2 September 2021

Kincoppal Rose Bay School
New South Head Road &, Vaucluse Rd
Vaucluse NSW 2030

RE: Planting blocking the Melocco Scroll elevation

SCALE: 1:200
 DATE: JULY 20
 DWG NO: KRB: JUNIOR: 01

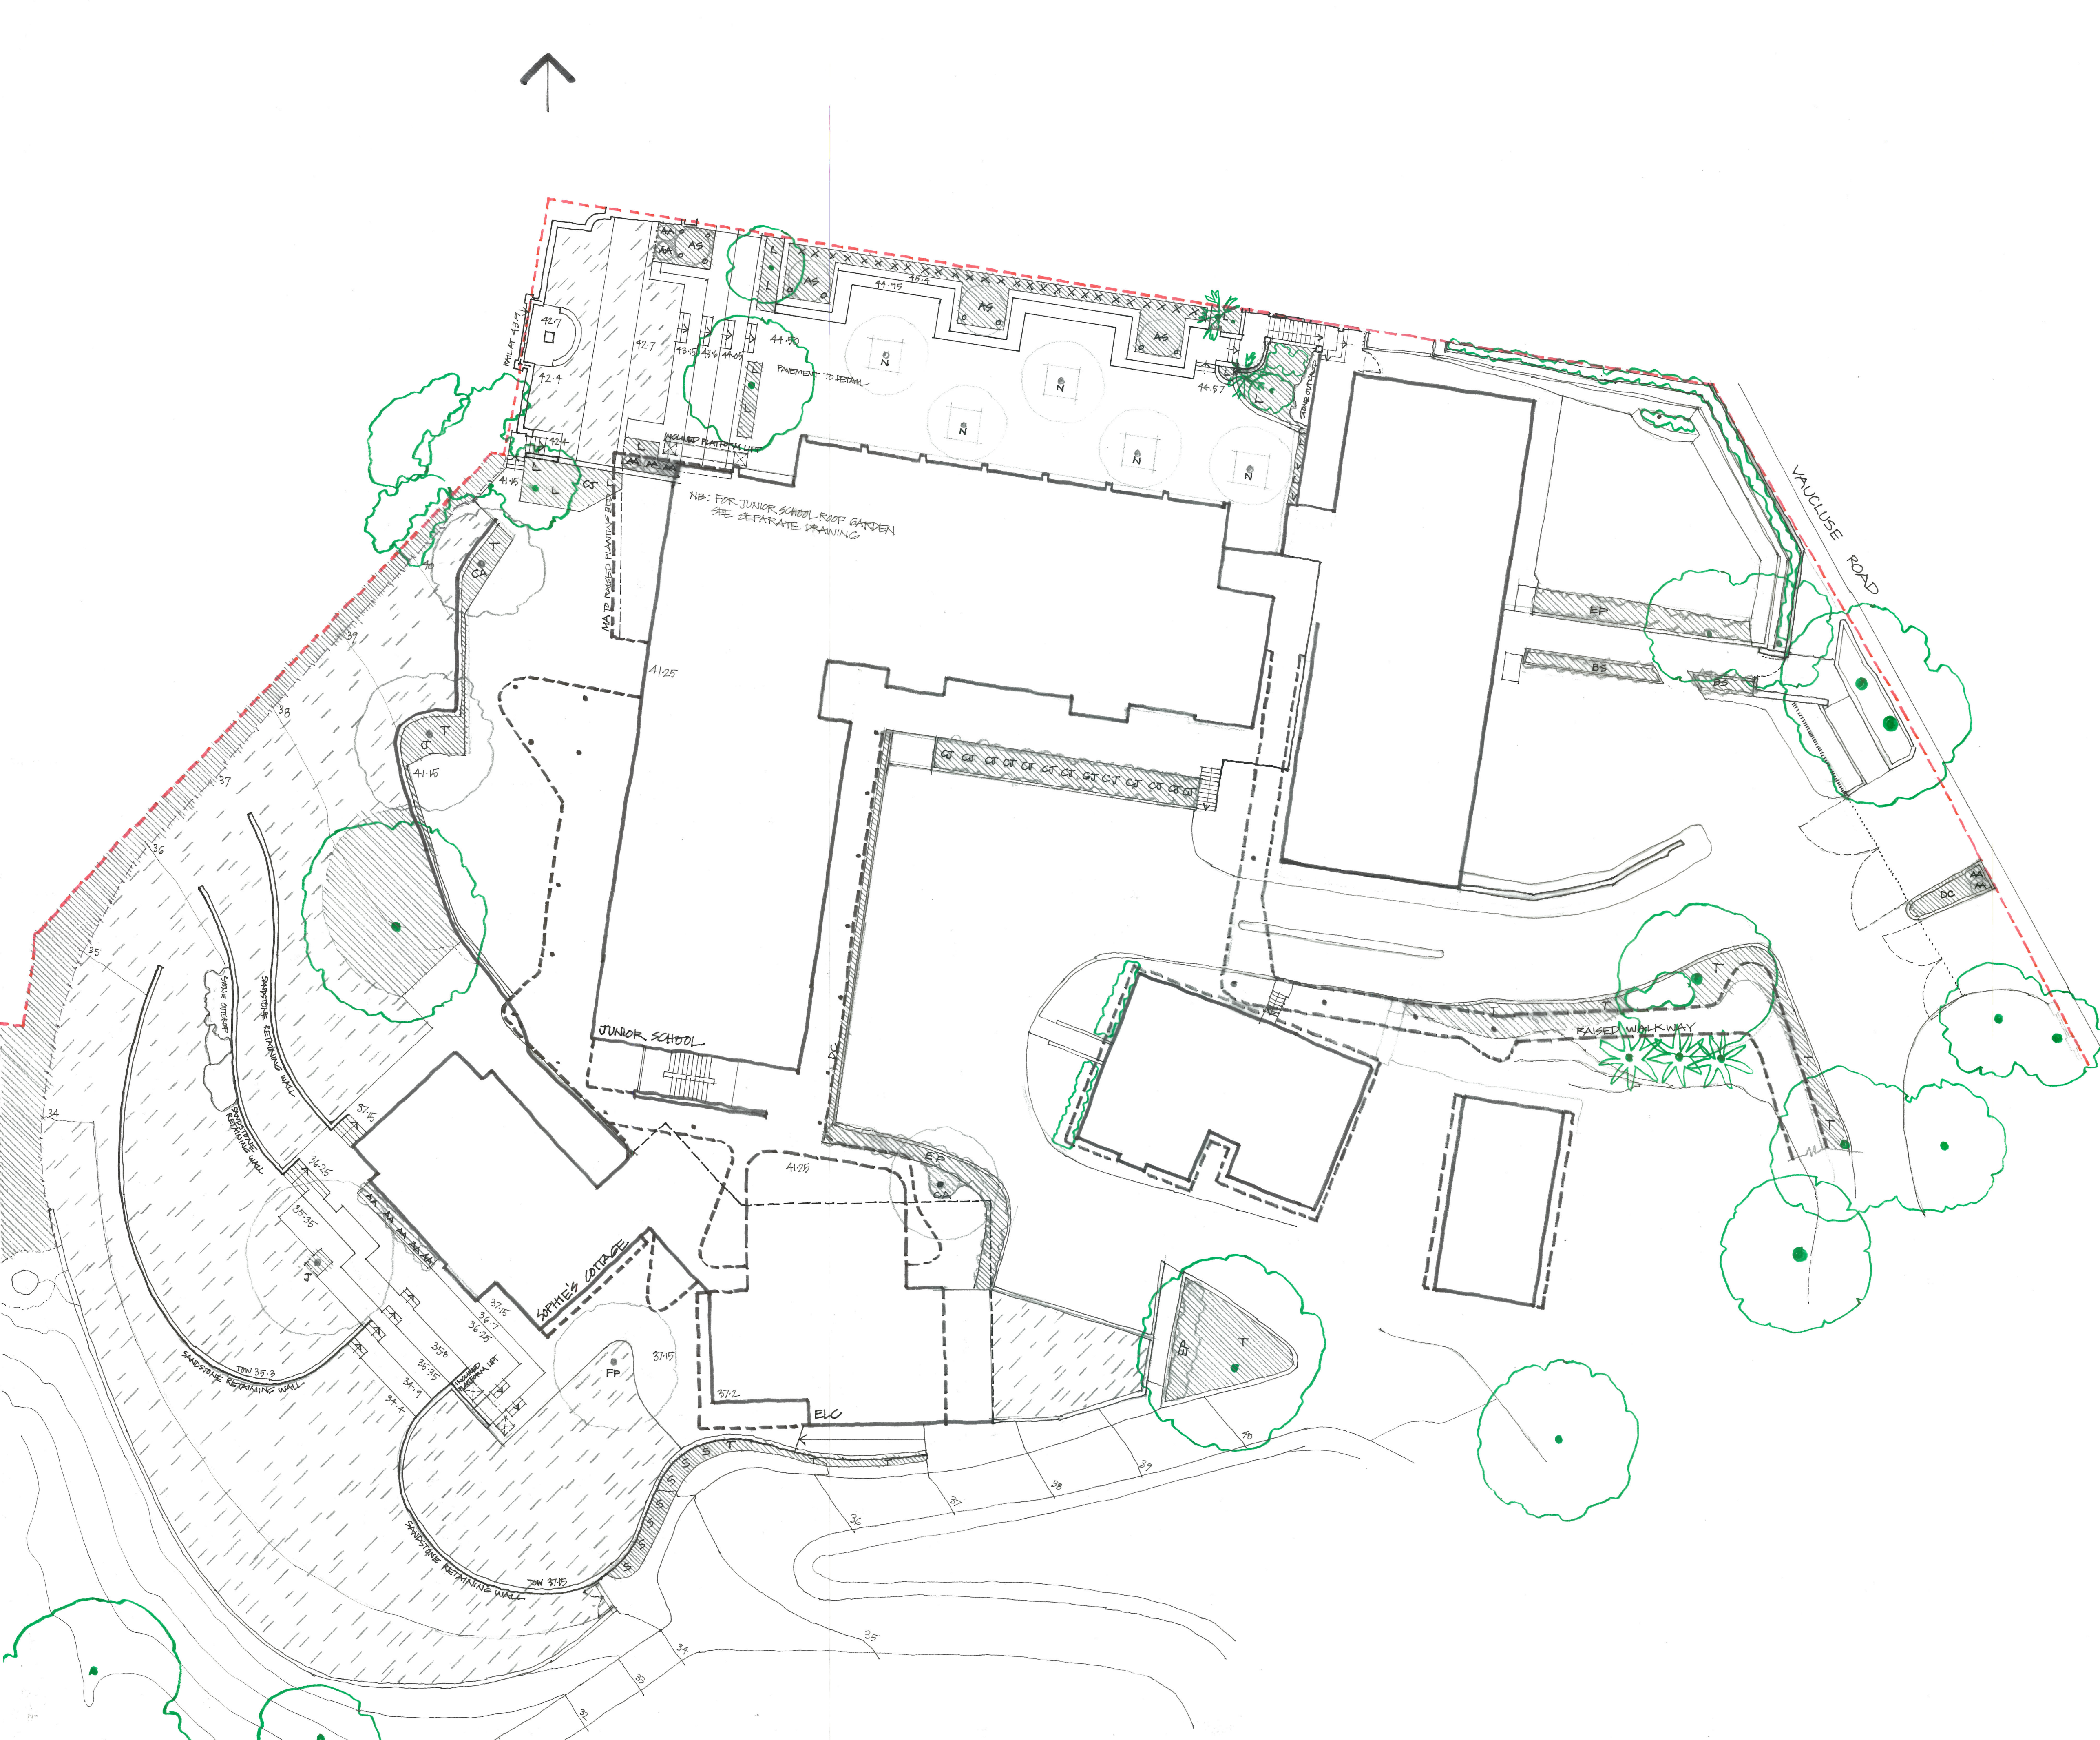
We have received and reviewed the Heritage Impact Statement post lodgments of the SSDA and agrees that the current planting design of the *Acmena smithii* 'Sublime' (sublime lilly pilly) will visually block the Melocco Scroll balustrade. We do not believe the remaining understory species will visually impact the Melocco Scroll balustrade.

Turf Design Studio recommends substituting the *Acmena smithii* 'sublime' with a *Waterhousea floribunda*. The *Waterhousea* should be under pruned to 3m during the maintenance period to prevent visual impact on the Balustrade.
